Our Ref: LTR03-01-20-776 RFI SSD
17552047.docxAttention: Andrew Cowan
Dear AndrewEmail: acowan@willowtp.com.auRE: SSD-17552047 – REQUEST FOR FURTHER INFORMATION

This letter is in response to the request from DPIE for further information that was a result of the initial review of the SSD-17552047 submission as part of the Test of Adequacy.

Figure 6: Trunk Drainage Infrastructure identified in the Draft Mamre Road Precinct DCP

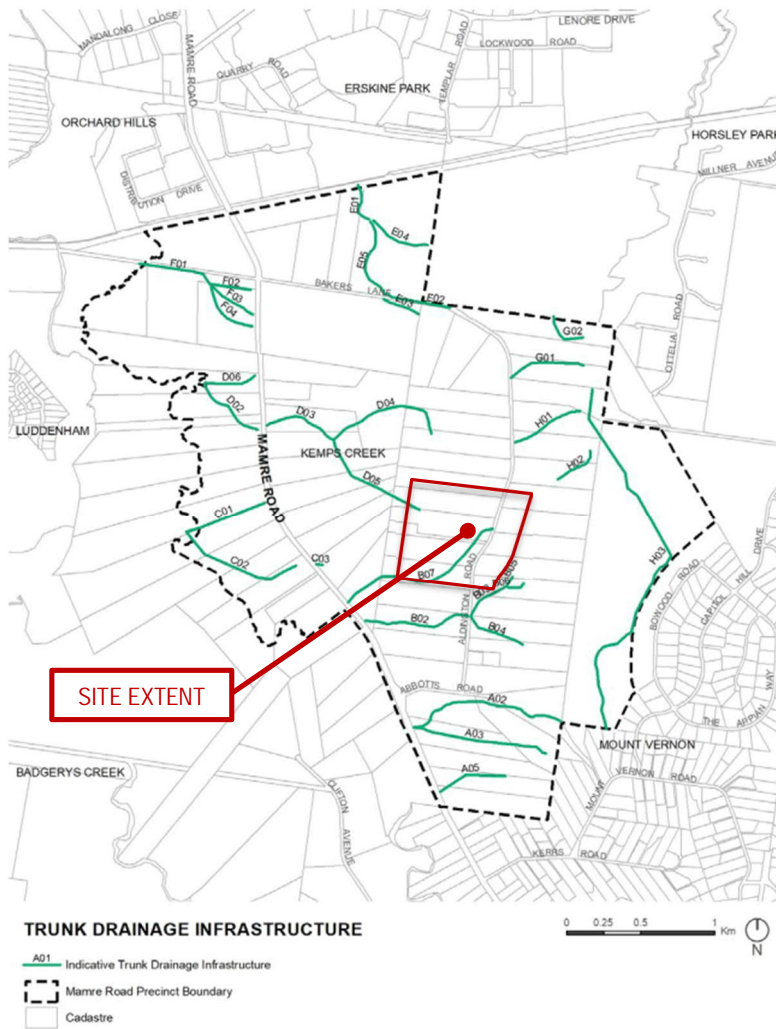
"The EIS and Appendix 8 refer to proposed stormwater drainage network in Road 1 and ultimately across the western boundary and into the future stormwater network on the Altis development site. Discharge to the Altis site will be subject to further design coordination. Please provide details of this arrangement, evidence of consultation with Altis including the timing and responsibilities for delivering this infrastructure. Please describe any easements which are required and shown these on a detailed plan."

Response; AT&L and Altis have been coordinating the future trunk drainage which runs through the Altis site (SSD-17647189) and then continues to the Mirvac site (SSD-10448). The trunk drainage has been coordinated and sized to cater for the storm events as outlined within the AT&L documentation. The drawings prepared by Costin Roe Engineers on behalf of Altis indicate the 1500 dia connection point for the project discharge point.

AT&L have continually coordinated with Costin Roe over the last 3 months to ensure the projects are coordinated. In the unlikely event the Altis development does not proceed, A temporary gabion level spreader will be provided to sheet flow the water over the boundary to mimic the existing conditions. In either case, we understand no easement would be required.

Figure 9: Extract of flood planning land map (Penrith LEP 2010)

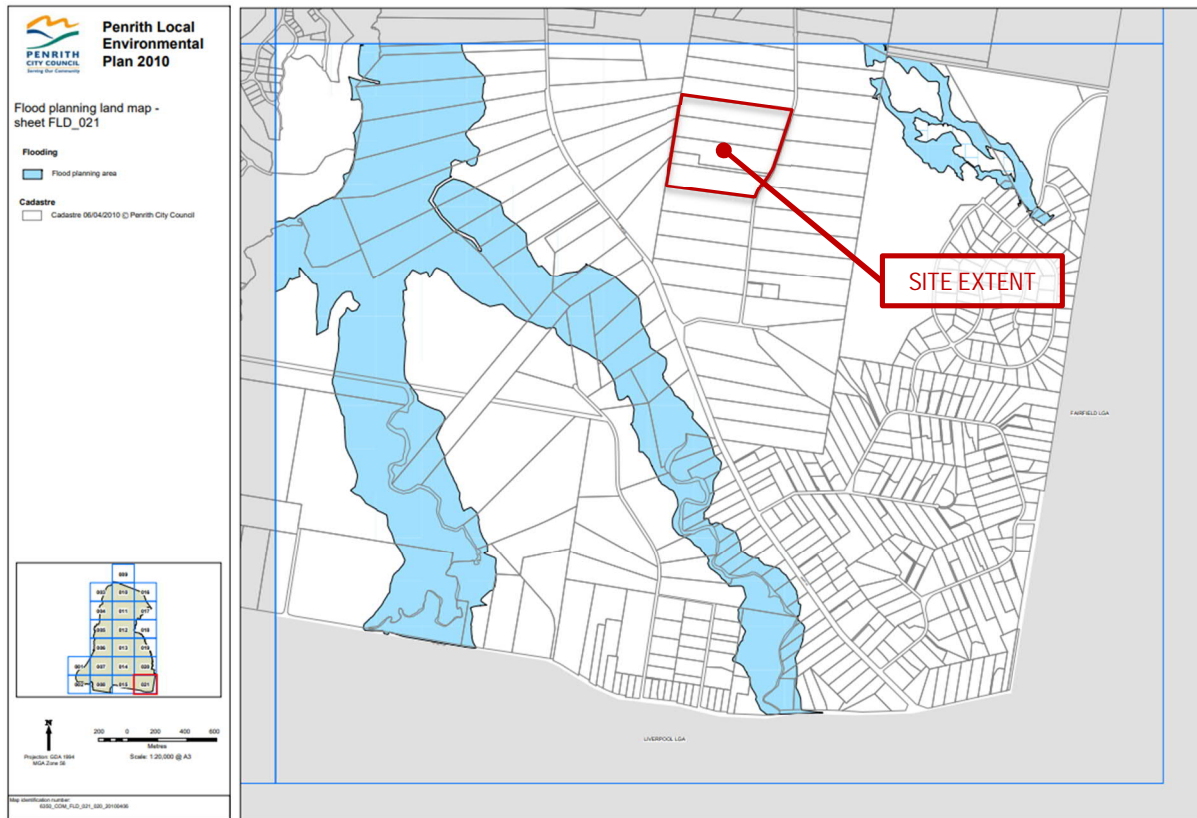
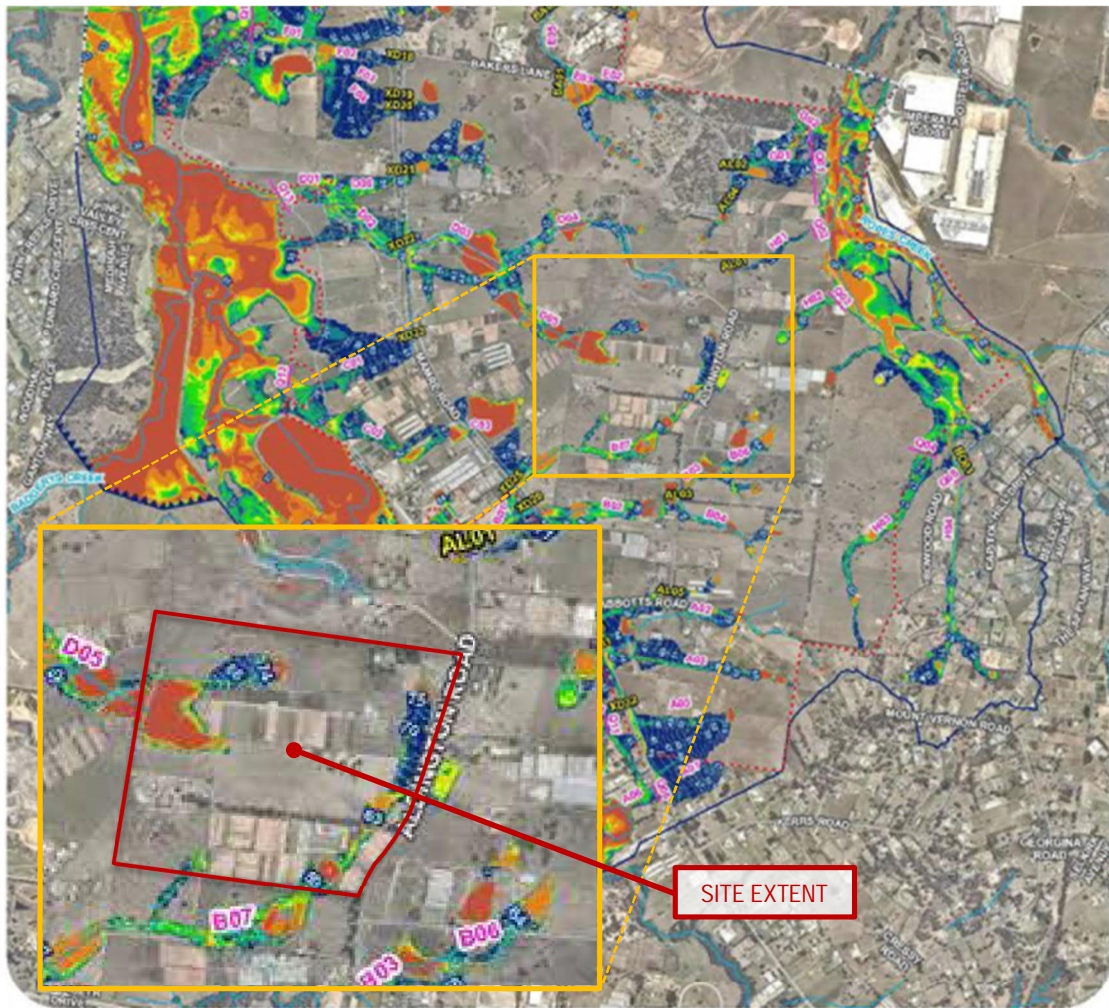
"The SEARs require a detailed flooding assessment. No assessment is provided in section 6.7 or Appendix 8. Please provide a flooding assessment or justify why a flooding assessment has not been included with detailed explanation and reference to the relevant statutory framework."

Response; The development has no creeks or mapped water courses or any significant external catchments. The entire site and flows within the site are being managed via an engineered pipe system along with On Site Detention maintain pre and post flows. Whilst flooding has been identified within Mamre Road Flood, Riparian Corridor and Integrated Water Cycle Management Strategy (Sydney Water October 2020), these extents of flooding are wholly contained within the Site. The AT&L Water Cycle Management Report (REP002-04-20-776) have been updated to include commentary on Flooding, refer Section 8.
